RE: Submission to MP09_0066 MOD 3 Thomas Street Carpark,
Chatswood

We wish to object to the proposed modifications to the Thomas Street Carpark development.

GROUND FLOOR PLAN

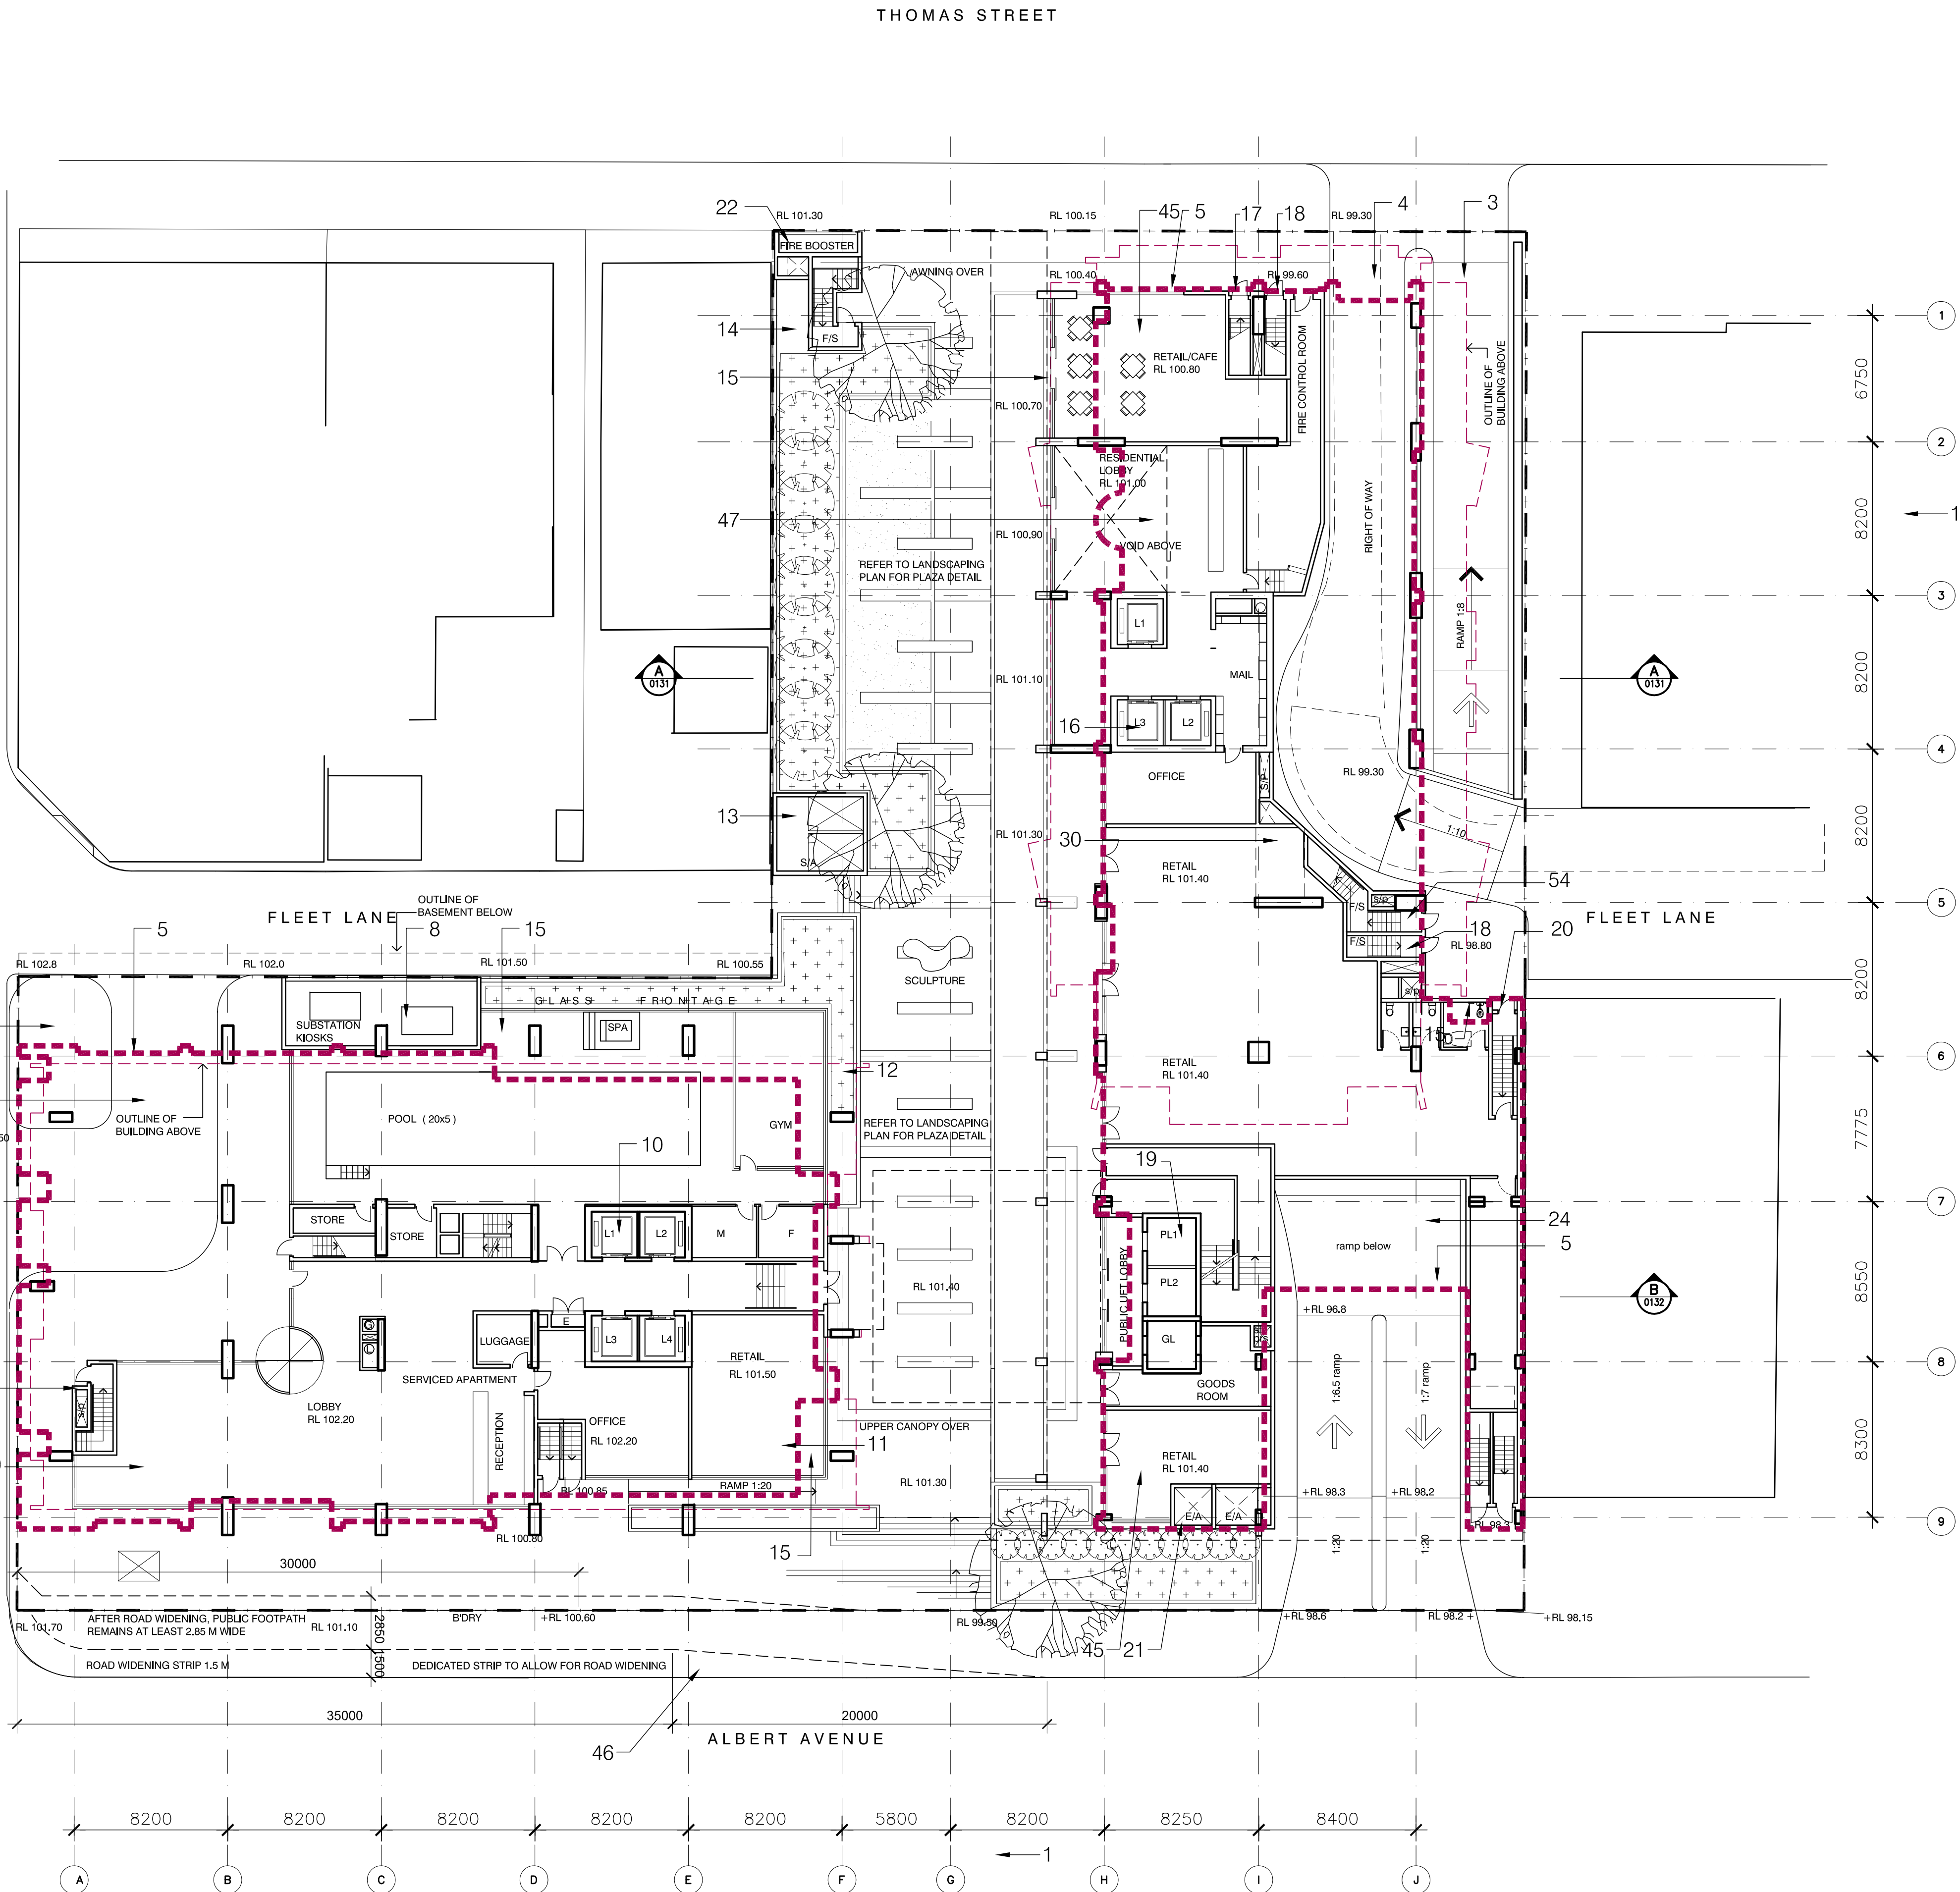
There has been and still is a lack of detail and regard for disabled access to 12 Thomas Street. We have people who are mobility impaired but not using a wheel chair, plus others in wheel chairs that require access to the disability ramp at the rear of our building.

The proposed access arrangements for the disabled are not clear, and from the information provided are dangerous at best.

There is no longer anywhere for someone to park near the disability ramp and drop someone off near it, or leave the car for 15 minutes and accompany them into the building.

The setbacks in the modification plans show that the building 1 is coming even closer to 12 Thomas Street and the childcare centre is right on the boundary. The outdoor play area is on the boundary and will be extremely noisy.
